DEVELOPMENT REVIEW BOARD
TRANSPORTATION DEVELOPMENT

DRB Project Number: 2020-003688
62nd Street

SUBJECT: Sketch Plat

DATE: January 12, 2022

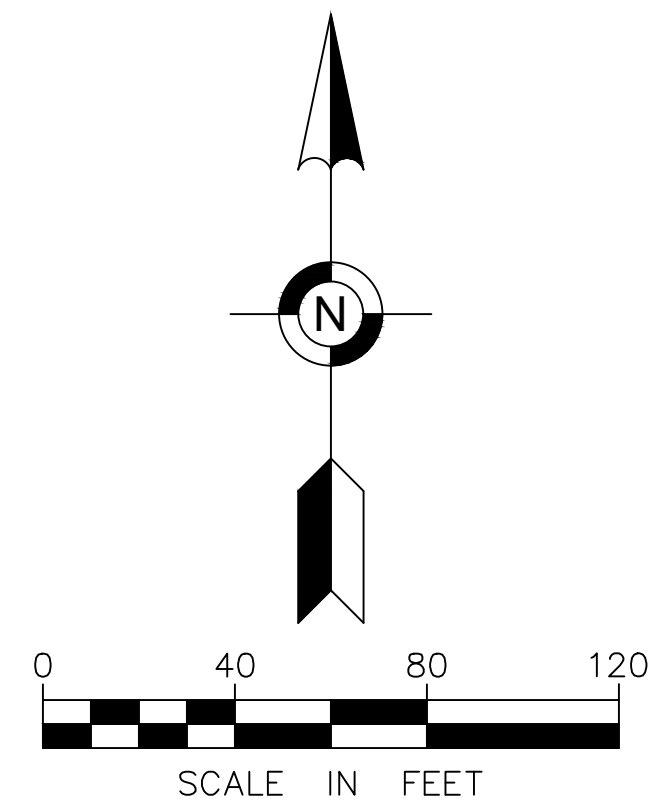
1. Provide a cross-section for the proposed roadway improvements. 5-foot wide sidewalk is the minimum required sidewalk width per DPM requirements. On the infrastructure list, specify both sidewalk, curb and turn-around under the item description. Curb and sidewalk shall be specified on "both sides".
2. On infrastructure list, separately list the access easement requirement and type of pavement proposed.
3. Variation from the 5-foot sidewalk requirements shall require a DRB Determination from DRB.
4. On the exhibit provided, show and label the existing Coors Blvd. sidewalk that is being tied into.
5. Verify with NMDOT that they concur with the layout since the proposed subdivision is adjacent to their right-of-way. Any work within NMDOT right-of-way requires a permit.
